**Our Case Number:** ACP-324568-26

**Re:** Proposed Development of the Barnesmore Gap Greenway Project  
County Donegal

Proposed Development of the Barnesmore Gap Greenway Project

Objecting against the proposed Trail head at Drumrooske Estate

Drawing file: Chapter 04 Description of the Proposed Development / 60701883-ACM-HGN-SW_ZZ_ZZ_ZZ-SK-HG-0003 Railway Road.pdf

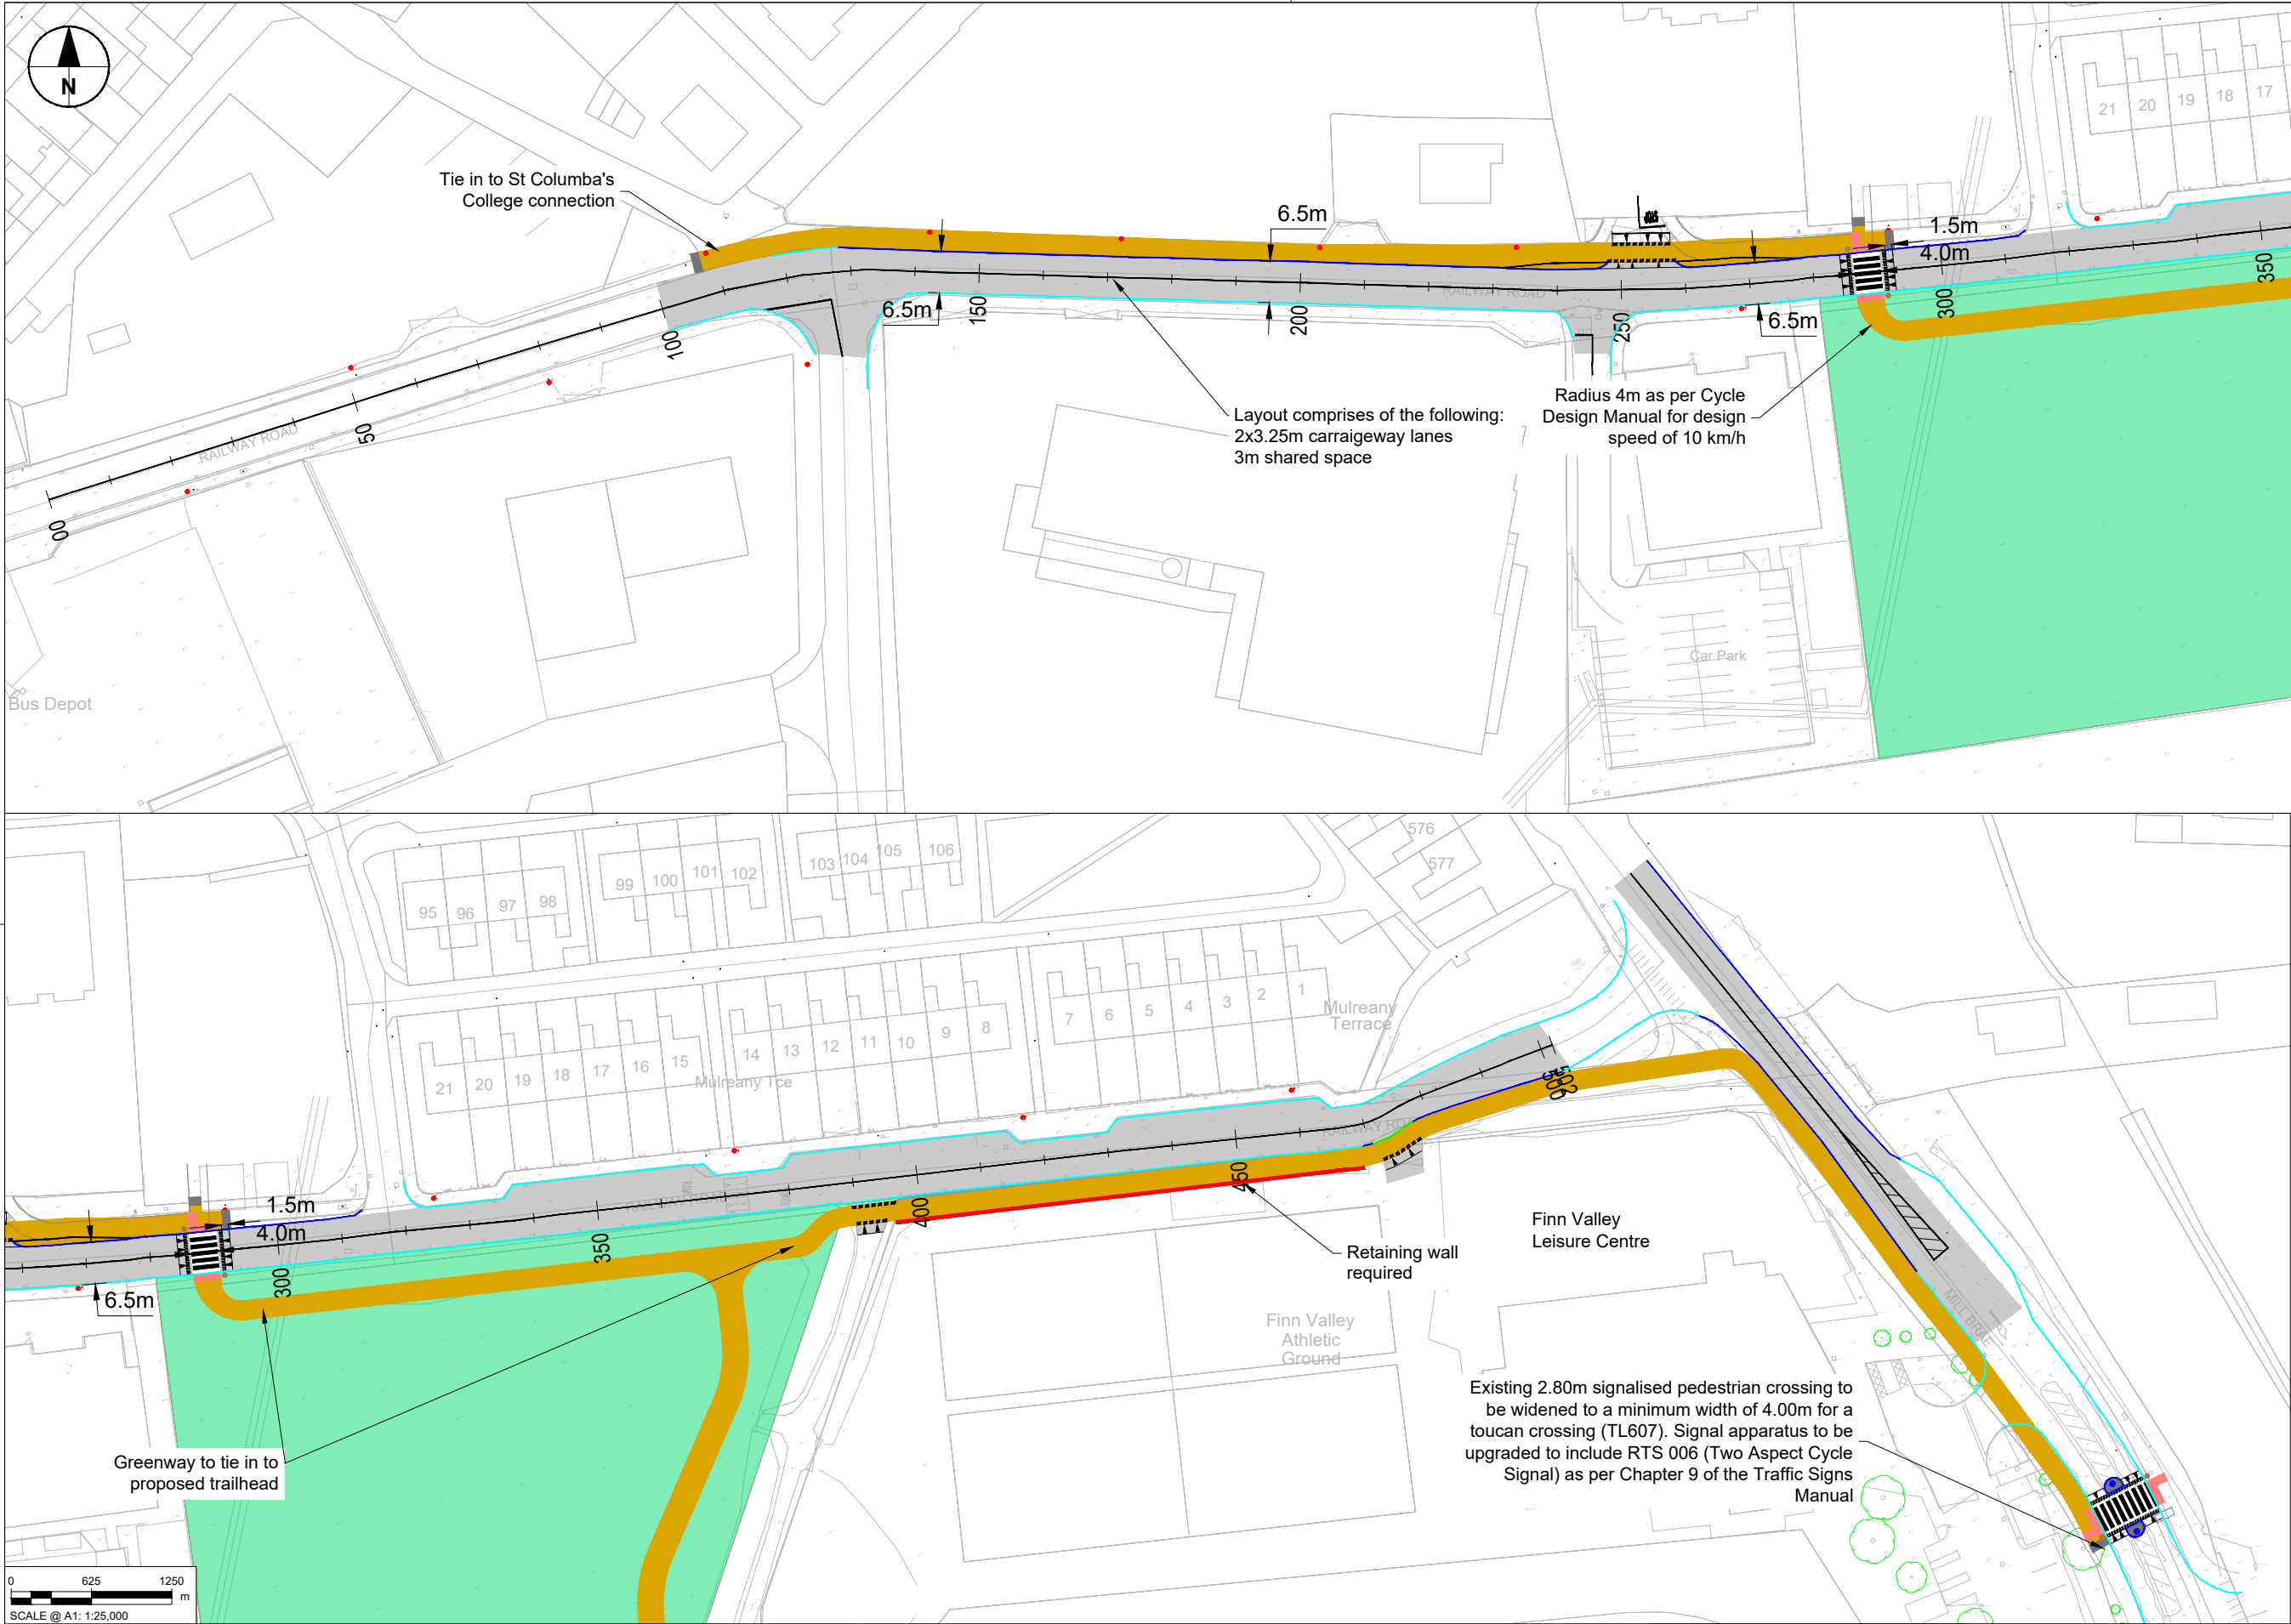
The proposal to realign Railway Road even closer to the houses on O'Cleirigh avenue is going to have a huge impact for the residents with the increase in traffic, noise and air pollution. At present there is a significant level for traffic noise coming from railway road especially late at night. Tesco's will bring a lot more of this late-night and early morning traffic to the area with deliveries in articulated lorries. O'Cleirigh Avenue was the first row of houses built in the estate back in the 1970s and it was always a very quiet and peaceful area up until recent years where it just seems to be getting busier and noisier. The residents here bought their houses in this location because of its peaceful location. I think Donegal County council should reconsider the realignment of Railway Road as most of these people are retired and want to enjoy the peace and quiet that brought them here in the first place.

The proposal to move of Railway Rd closer to the estate exit could possibly result in the creation of a dangerous junction. The Tirchonail St road is coming down a hill and sweeps around to the right at about a 40-degree angle. It currently has two exits one from Drumrooske and one from Railway Rd both of which are on the outside of this bend which does improve visibility for drivers but only over a short distance especially for the Drumrooske exit. The speed that drivers come down around that bend is probably too fast because if you pull out when they are just at the top of the hill, they will be most likely on your bumper before you reach the Railway Rd exit. Please see attached images.

Drivers coming down the road listed as Tirchonail St from the Lough Eske Rd, heading around a bend will have to look out for cars exiting out of 7 exits before they get to the bridge by the castle. Two of which exits are side by side, labelled exit 1 & exit 2 and all of which will have pedestrians crossing. With exit 2 being the moved (Railway Rd) closer to Exit 1 at O'Cleirigh Avenue I believe this will pose the biggest risk to pedestrians and motorists. Please see detail sketch.

At present when people leave the estate (Exit 1), they can often be seen tail gated over the road by speeding drivers coming down from the Lough Eske Rd at the T junction. If this happens when someone else pulls out the new proposed road placement (Exit 2) then there is going to be a lot of close calls if not accidents. Or if a car is coming down from the T junction and watching out to make sure a car leaving the estate (Exit 1) doesn't proceed in front of them, they may very well miss a car exiting from railway road (Exit 2). At least where railway road currently is, the driver coming down the way only has to look out for one exit at a time instead of 2 exits side by side not to mention looking out for pedestrians crossing these exits. This road is very busy especially at playschool/schools opening and closing hours. There is also a hidden dim in the road just at the bosco centre that is extremely dangerous as parents have to cross the roads to leave kids off to the playschool there.

Figure 3-2 - Donegal Trailhead

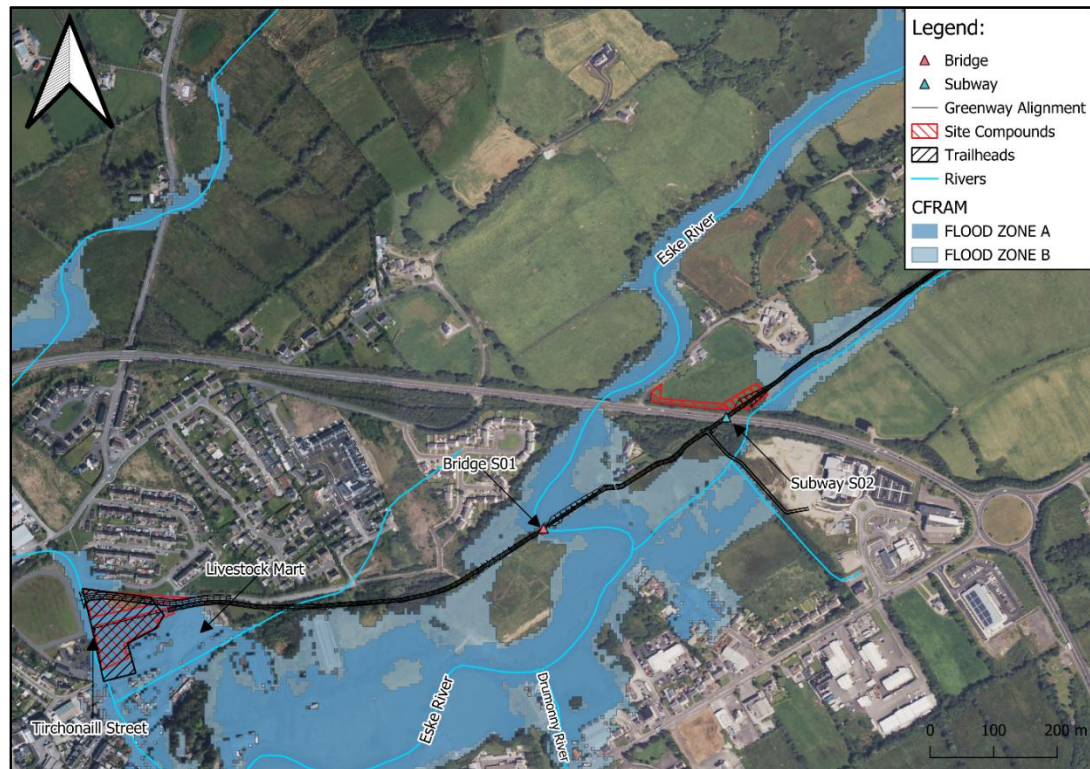
**I believe the above to be incorrect on a few things.**

- 1) The Trailhead is not located at the St. John Bosco Community Centre. It is located in a green space in front of O'Cleirigh avenue with Railway Road currently to the opposite side. I was informed by plenty of residents that this field is owned by the council but given to the people in the estate back in the 80/90s as an amenity grassland which the residents maintained for decades. There was always a collection to help with the cost of maintaining this green area/amenity grassland. When railway road was put in, it halved the amenity grassland which the Bosco centre claimed the section closet to them and we were left with a reduced amenity grassland. This reduction will see a decrease in the minimum required usable green space for residents, leaving children with minimal play areas.

- 2) This is an extension to the Bosco centre which is then being called a trailhead for the greenway with the addition of unwanted public toilets, benches and tents. This pay and display parking will be accommodated by workers from local businesses during the day and people attending the Bosco centre in the evenings for events such as bingo on a Thursday night for example. I think the design is misleading and being disguised as Greenway trailhead parking then that will clearly not be the intended use. I believe the intended use is to profit from the workers who currently park for free in the Bosco centre carpark. Anyone hoping to use the greenway will probably find it hard to get a parking spot and as a result will park in front of the houses in the residential parking zones created by the council for the residents of Drumrooske estate back when the houses were built in the early 70s. The estate is mostly privately owned now by residents and many have purchased their homes with the benefit of having parking on site. There is a serious issue with parking in the town at present and I think this is just one step towards resolving that issue.

- 3) It states above that there will be 1 space allocated for a mini bus which I believe to be misleading as it was mentioned to me at one of the consultations about buses, not just 1. On the plans it also shows 2 buses parked alongside the road in an area which can accommodate at least 4 buses. I believe the intended use here is to get the Bus Eireann buses out of the diamond in a bid to ease the traffic congestion created by the recently introduced 1 way system which has seen a huge increase in congestion in the town, even when there are no buses present. This will just build up the even more congestion along Tirchonail St. It will not solve any problems but instead redirect them.

- 4) To say there is only a 1% Annual exceedance probability of flooding is incorrect. The area is widely known as a flood plain and there are more than ever greater chances of floods here with climate change which brings much heavy prolonged thundery downpours. I have provided some details on the flooding at Drumrooske below which I hope gives a greater insight to the bigger picture in regards to flooding.
